**WELWYN HATFIELD BOROUGH COUNCIL  
EXECUTIVE DIRECTOR - PLANNING, PUBLIC PROTECTION AND GOVERNANCE**

**DELEGATED APPLICATION**

**Application No:** 6/2022/1057/EM  
**Location:** 175 Parkway, Welwyn Garden City, AL8 6JA  
**Proposal:** Installation of hardstanding in front garden  
**Officer:** Mr James Homer

175 PARKWAY - PROPOSED PLAN

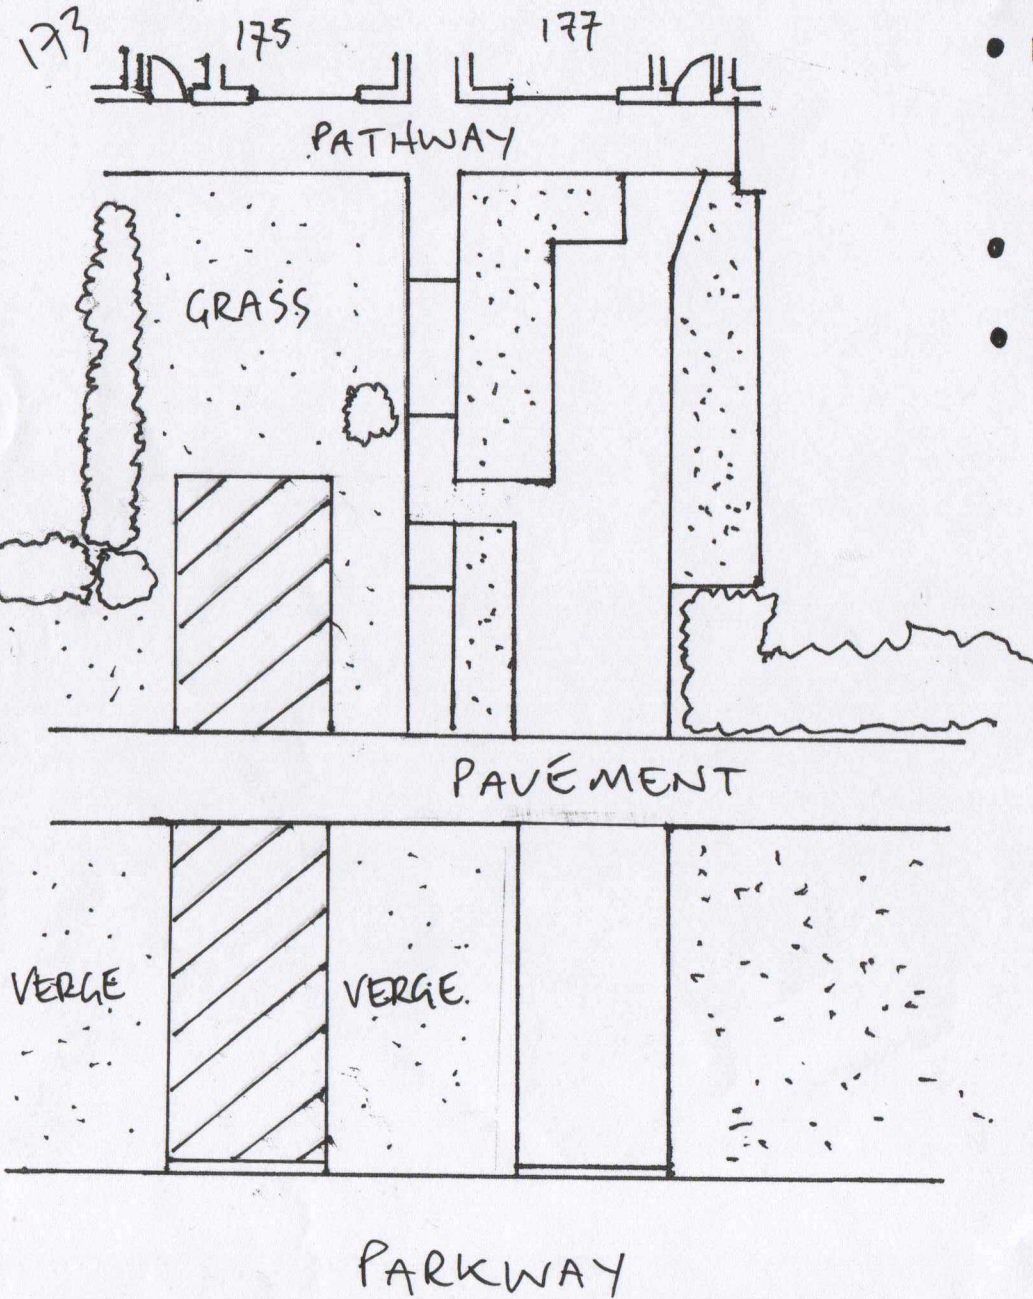
<b>amenities and values of Garden City)</b>	<p>'green' landscaping to help preserve the character of Welwyn Garden City. In addition, works must not result in the loss of any existing hedgerows or landscaping along the boundary other than the minimum required to access the hardstanding.</p> <p>Approximately half of the hardstanding proposed for car parking would be installed on land outside of the application site. The section to be installed within the front garden would be significantly under 50% of the front garden and therefore sufficient soft landscaping would be retained.</p> <p>To allow the formation of and access to the hardstanding, the application proposes to remove the majority of a front hedgerow. There is a mixture of open and enclosed frontages within this area of Parkway, therefore the removal of this hedgerow would not result in marked change in the character of the area.</p>

<b>Impact on neighbours</b>	The proposed hardstanding will not result in a loss of amenity to neighbouring homes in terms of loss of light, outlook or privacy.
<b>Landscaping issues (incl. hardstandings)</b>	See above.
<b>Any other considerations</b>	None.
<b>Conclusion</b>	
The installation of the hardstanding identified for the front garden would not result in a harmful loss of soft landscaping and the character of the area would be maintained. The application therefore, complies with Policy EM4 of the Estate Management Scheme.

5. Only that part of the hedge required for the access of the hard standing shall be removed and the remainder shall be retained.
